KITTITAS COUNTY DEPARTMENT OF PUBLIC WORKS

MEMORANDUM

TO: Kaycee Hathaway, Community Development Services
FROM: Christina Wollman, Planner III *CW*
DATE: August 7, 2014
SUBJECT: Leensvart BL-14-00015

LOT LINE ADJUSTMENT

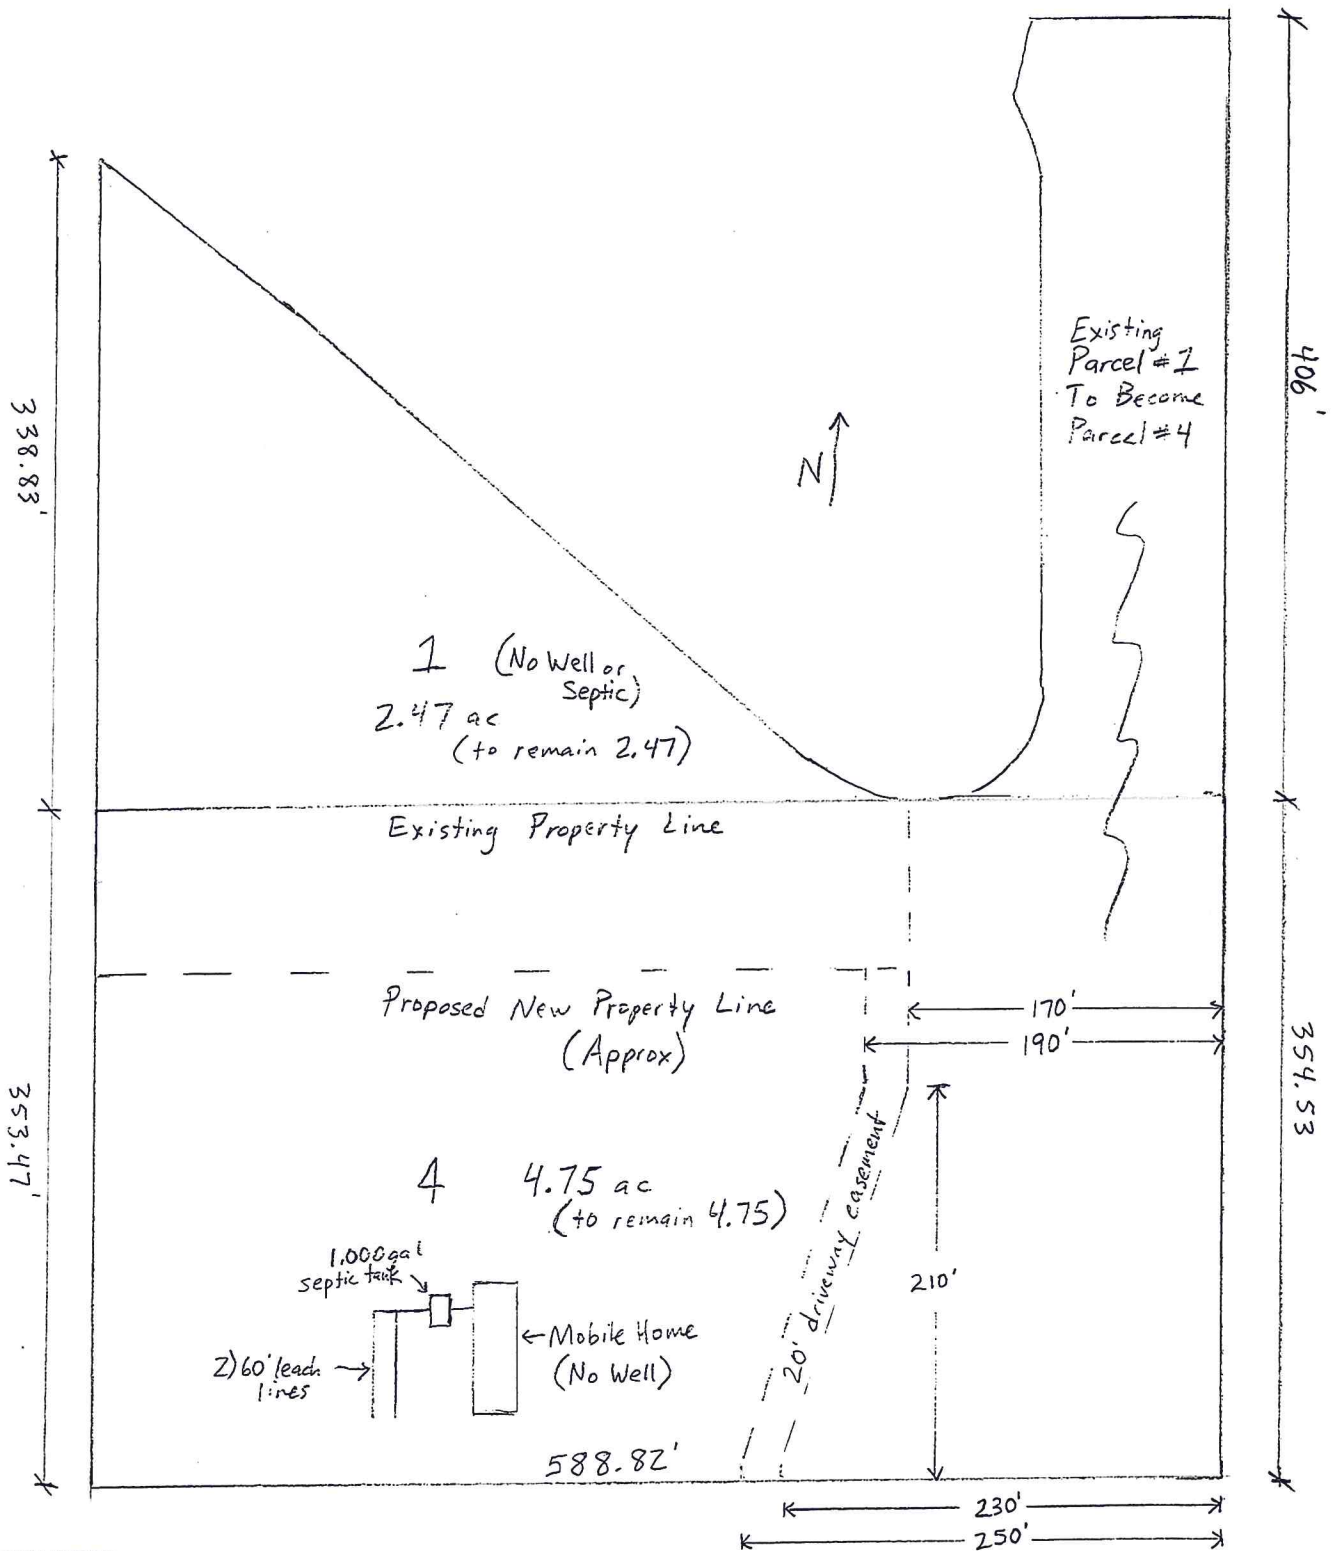
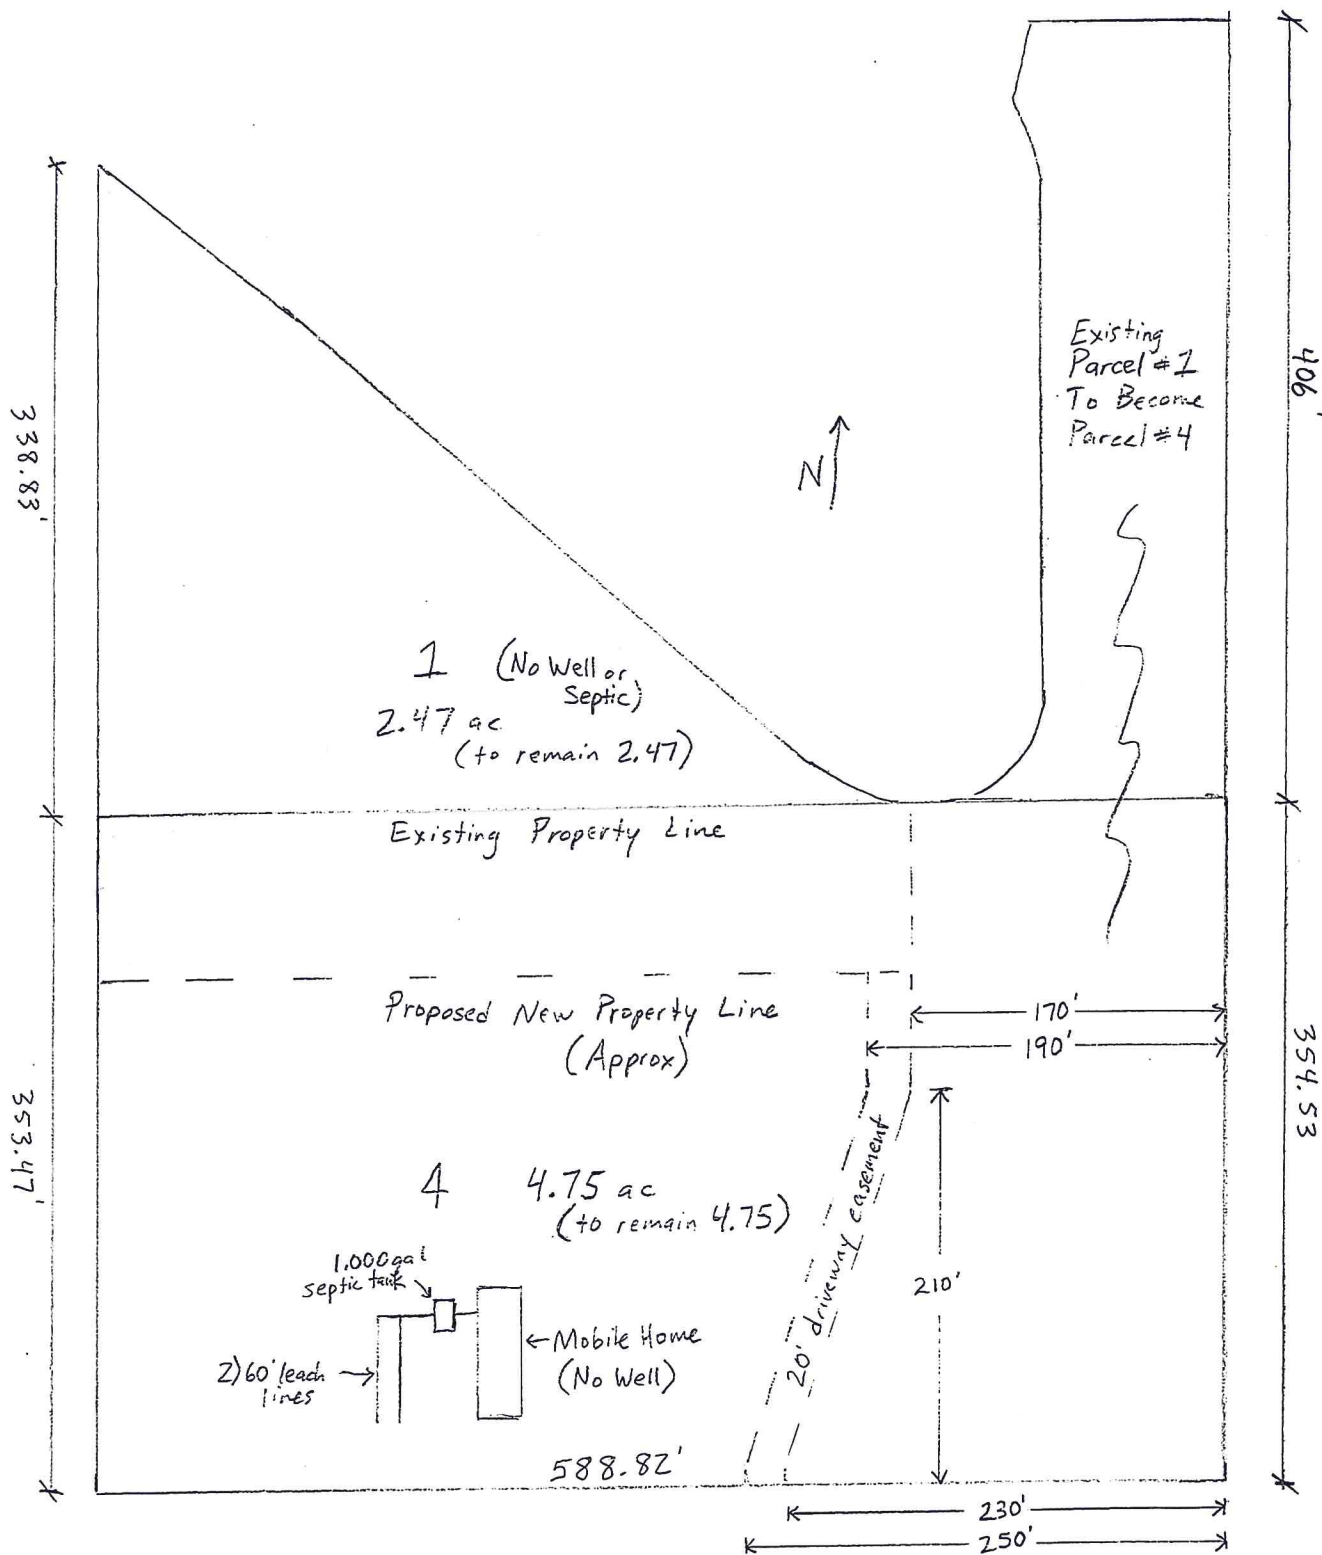
1. A revised legal description that describes the final configuration of the subject property shall be required.
2. The 20' driveway easement shall access the county road at the location of the existing driveway.
